MEMORANDUM

DATE: January 20, 2023

SUBJECT: SF-22-037 – Sterling Ranch East Filing No. 2
First Submittal

Engineering Division

# STERLING RANCH EAST FILING NO. 2

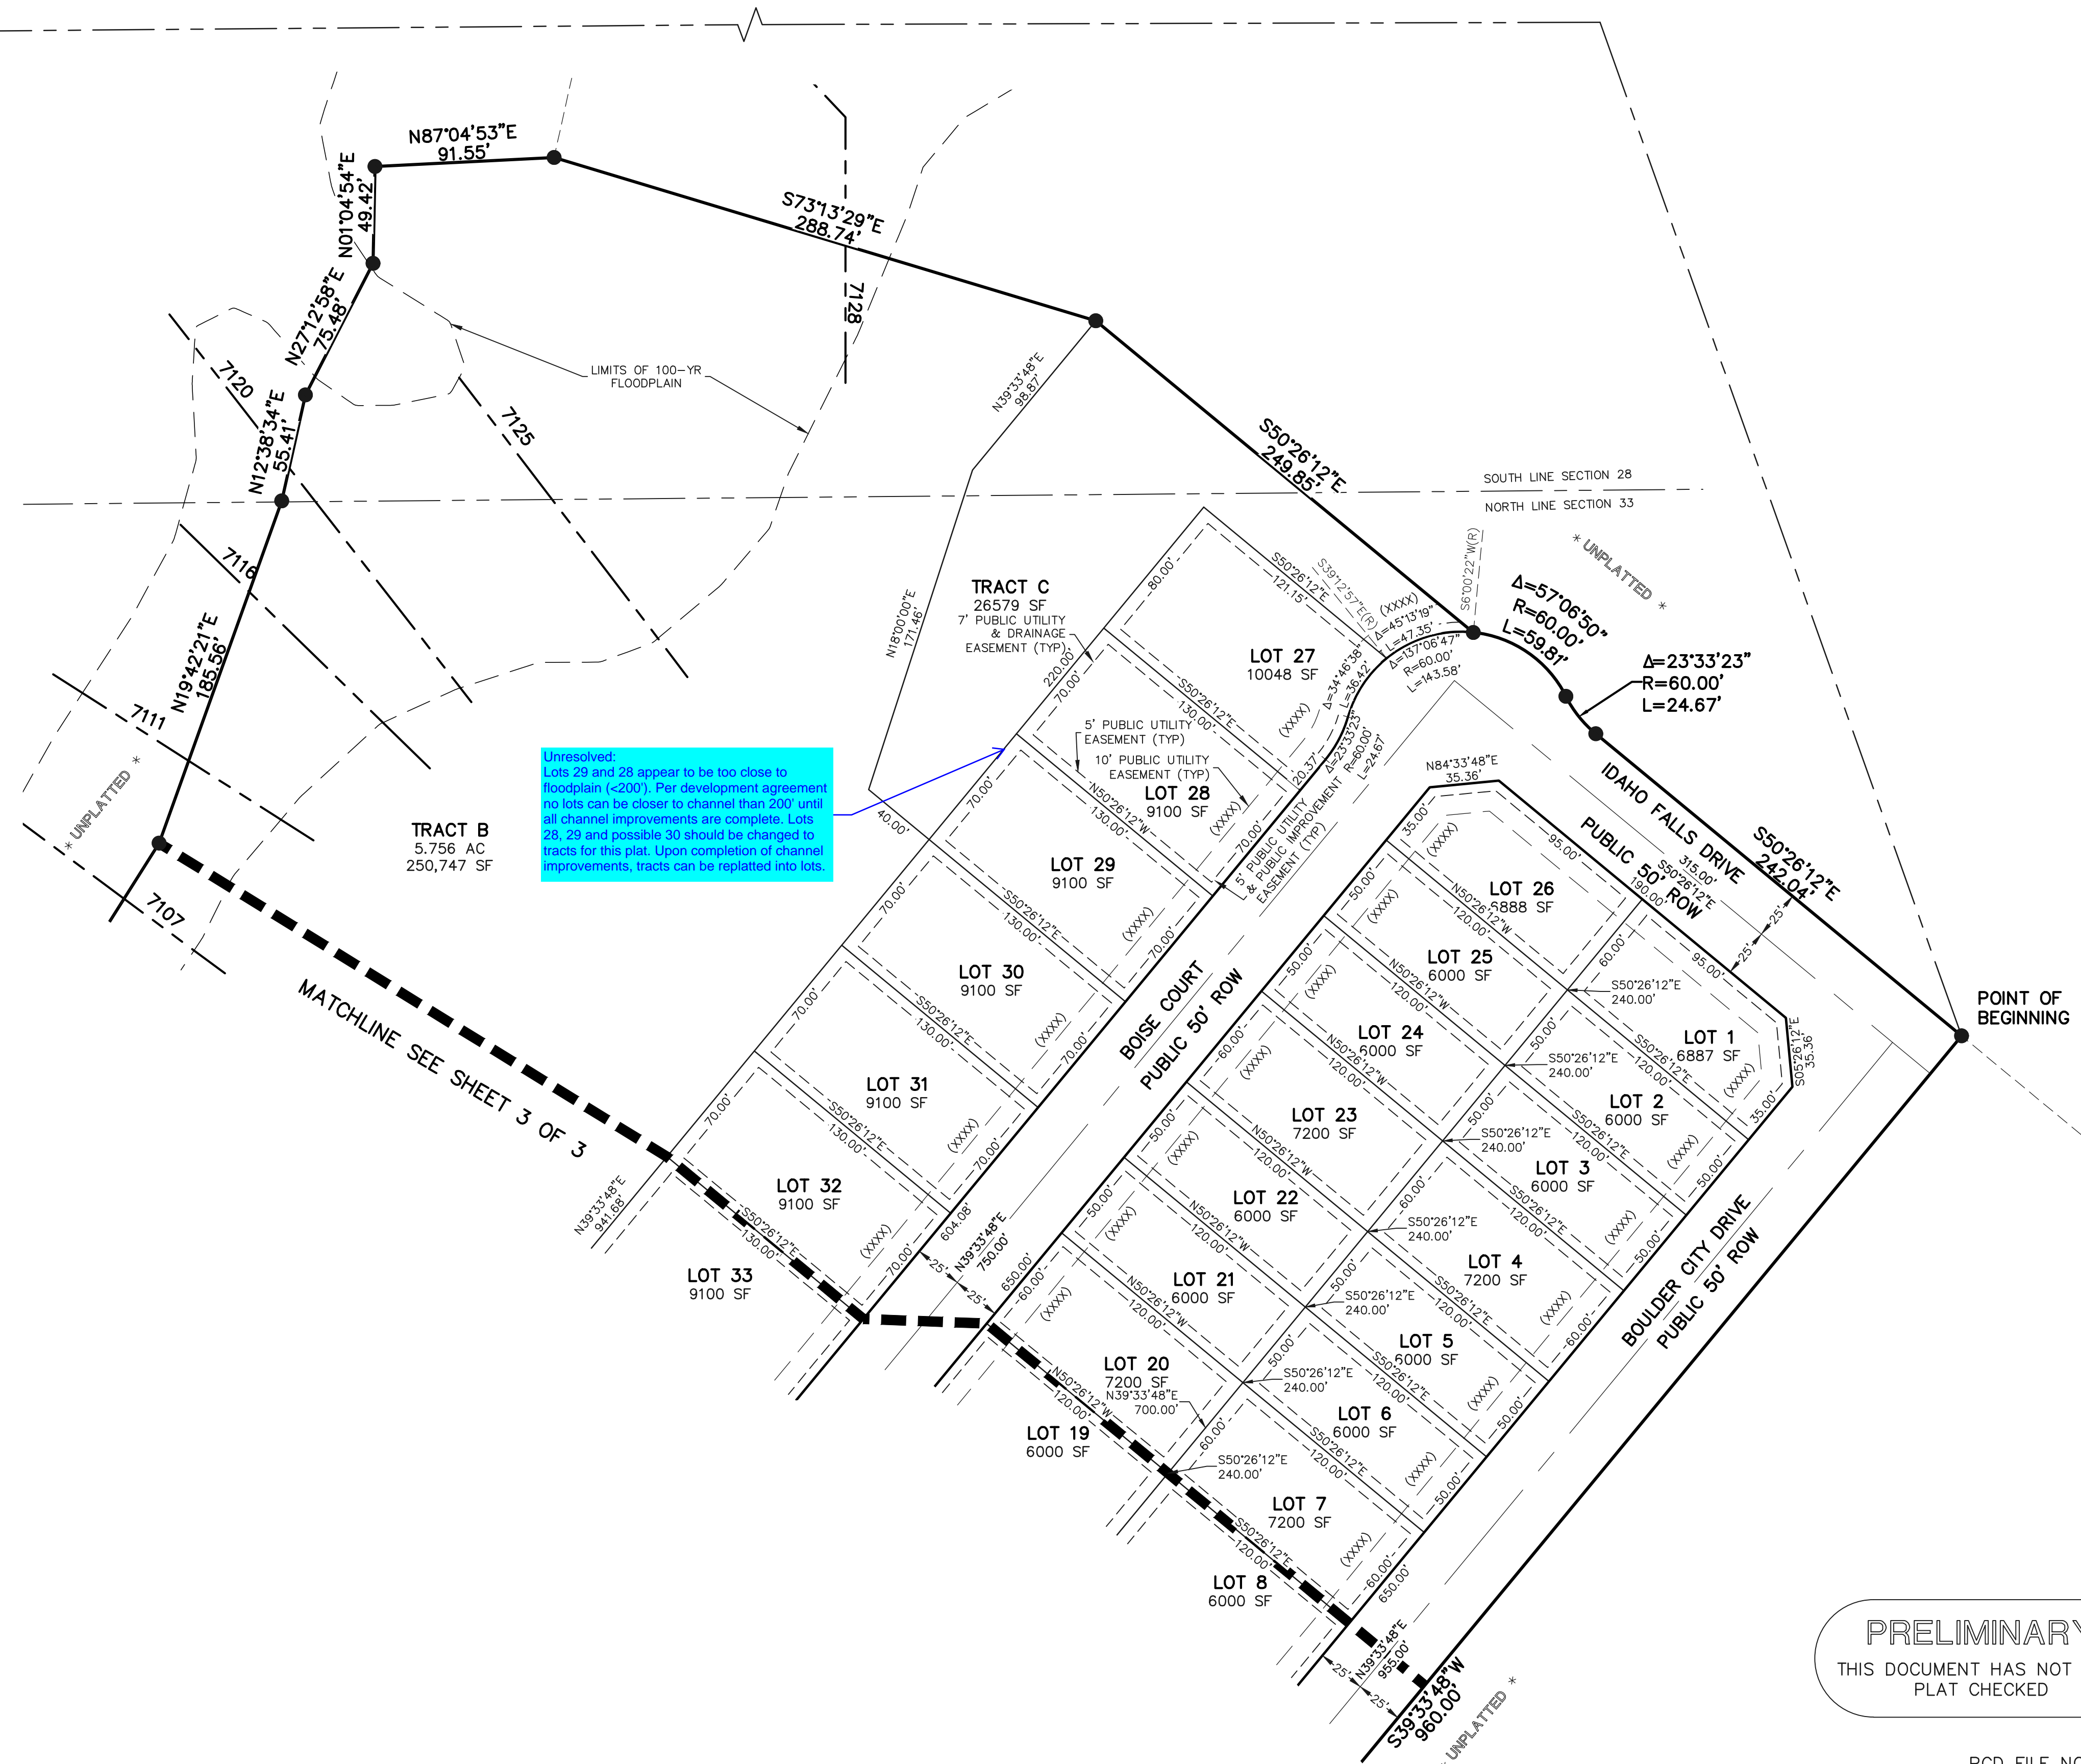
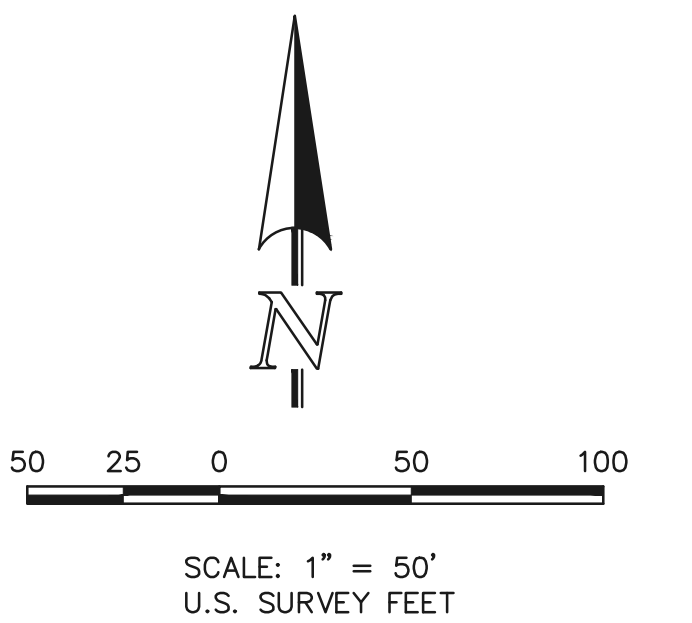
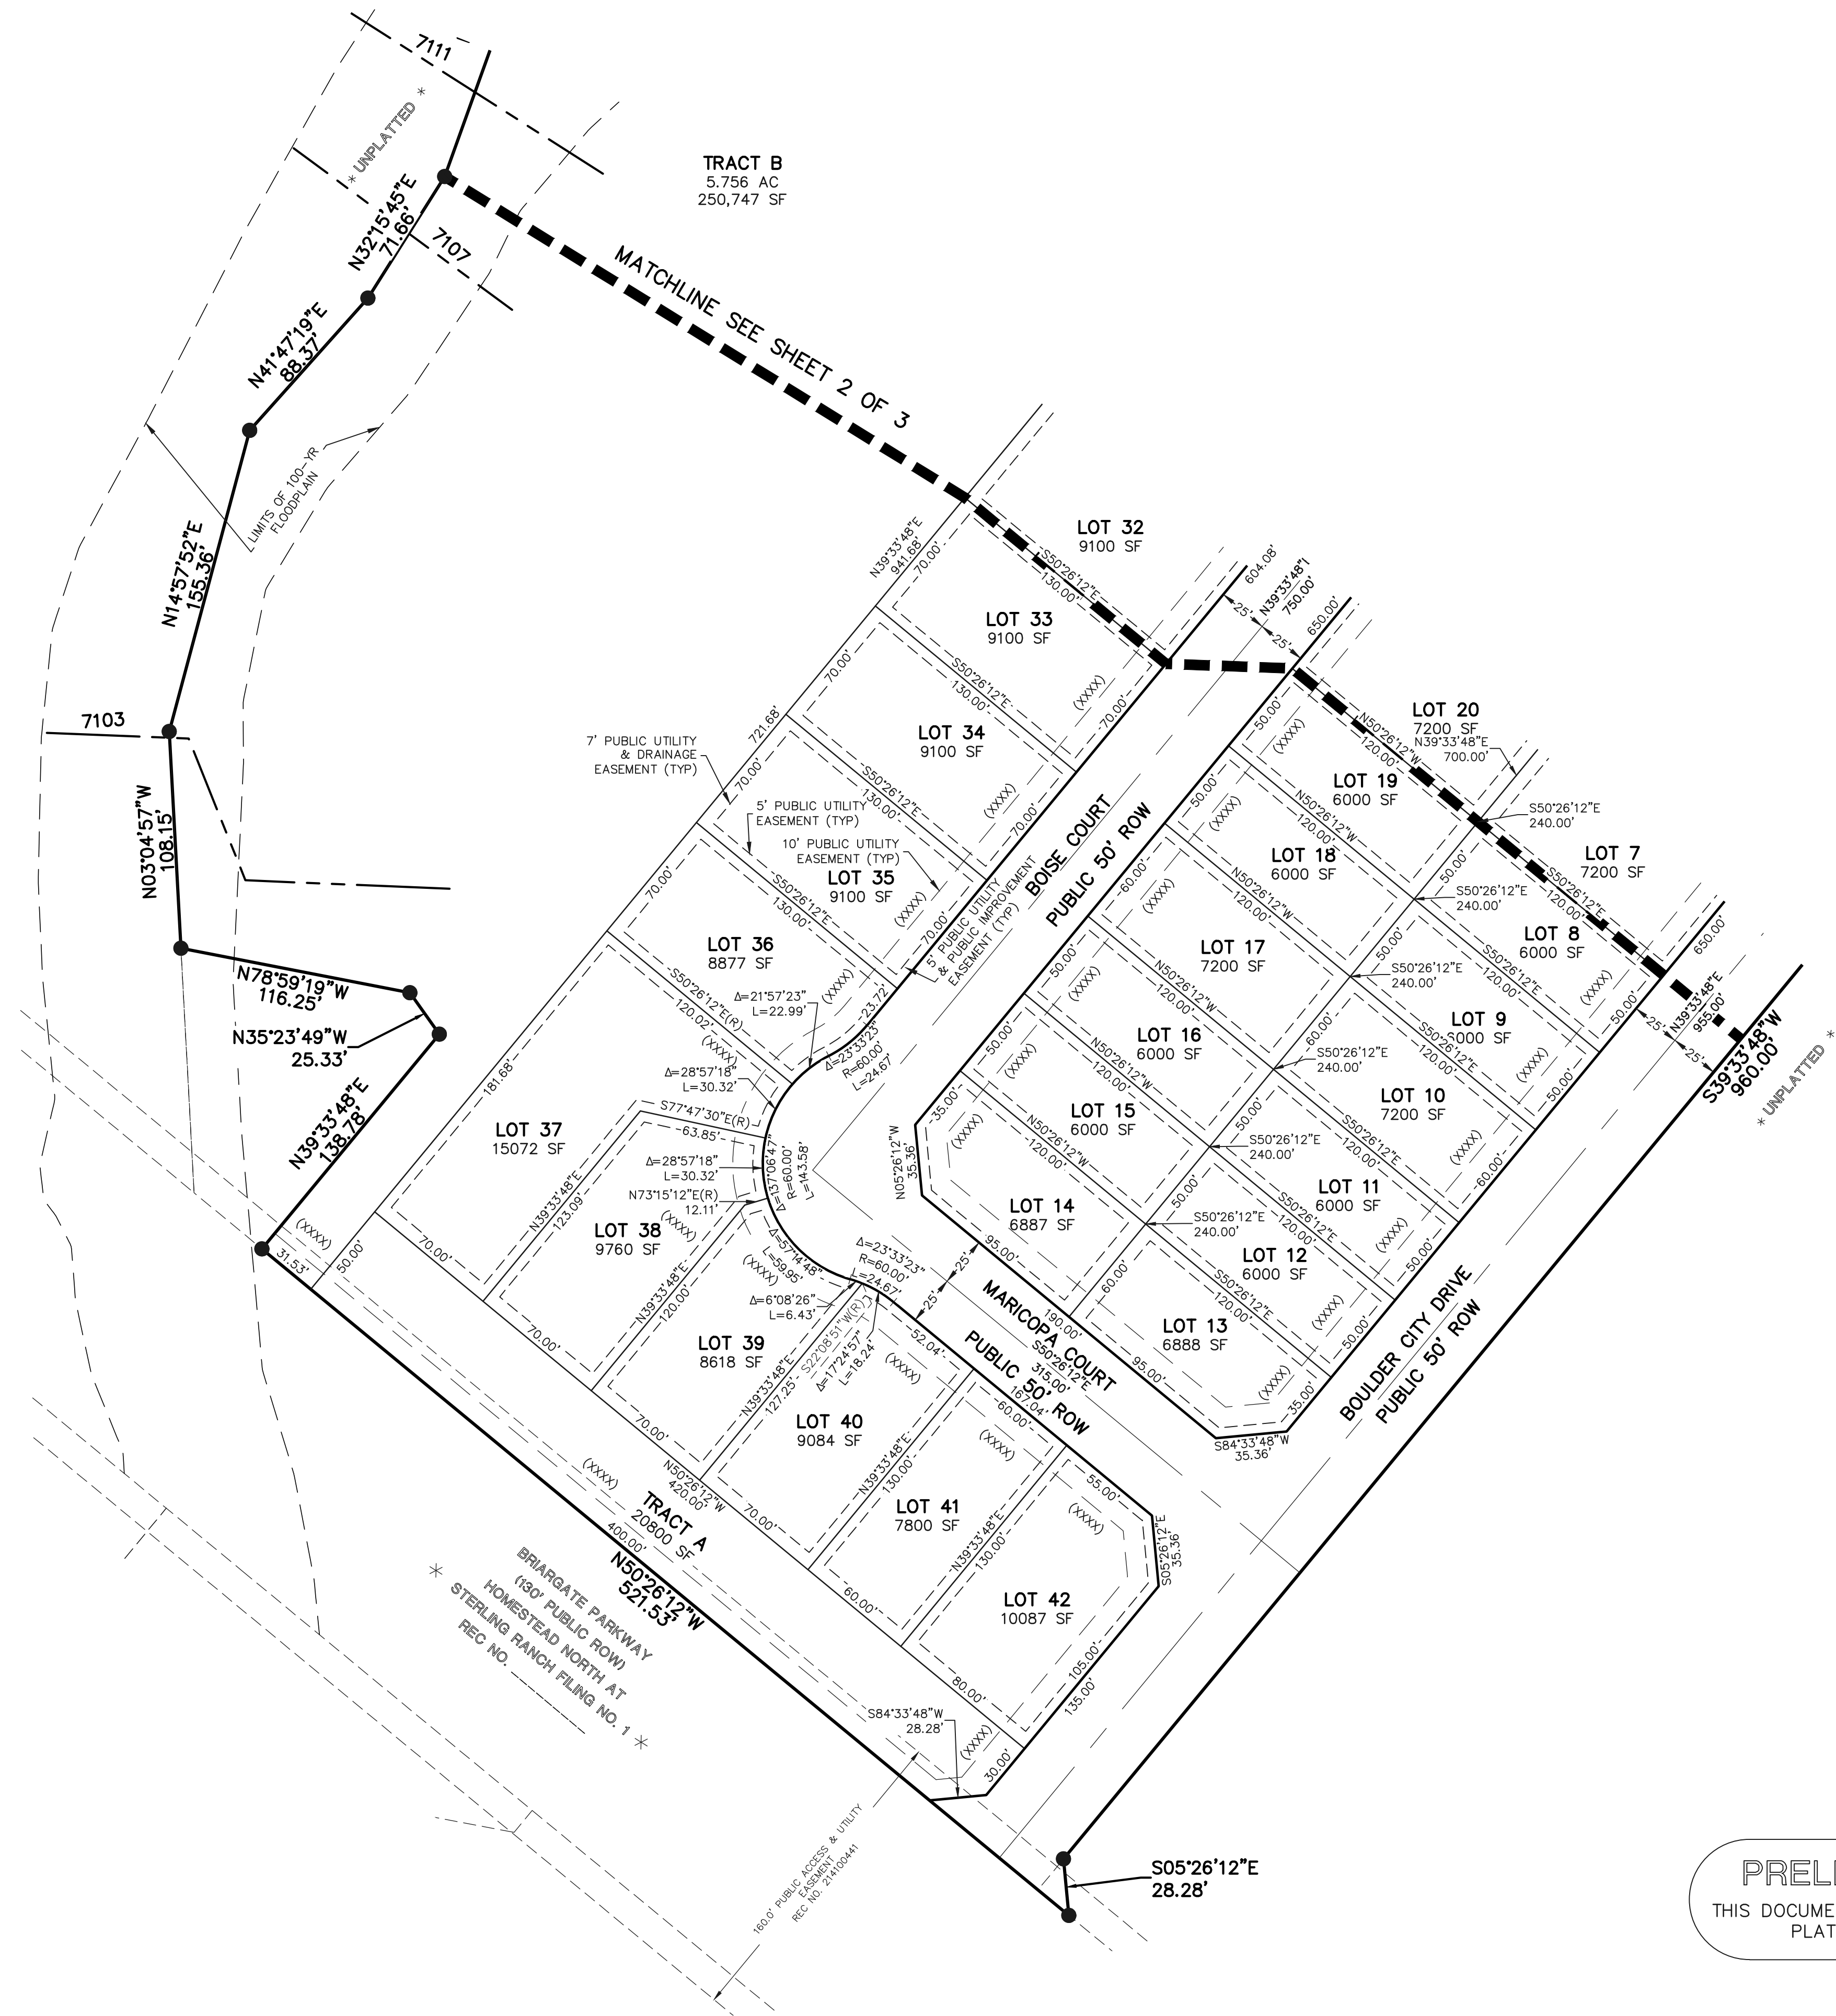
2. Note: per the Development Agreement: “Subdivider and its successors and assigns, including homebuilders, shall not be permitted to plat any lots within two hundred (200) feet of the east side of the existing Sand Creek floodplain between Briargate Parkway and Sterling Ranch Road prior to completion of the Sand Creek Channel Improvements.”
3. Note: Carry through any revisions from the preliminary plan onto the final plat documents.
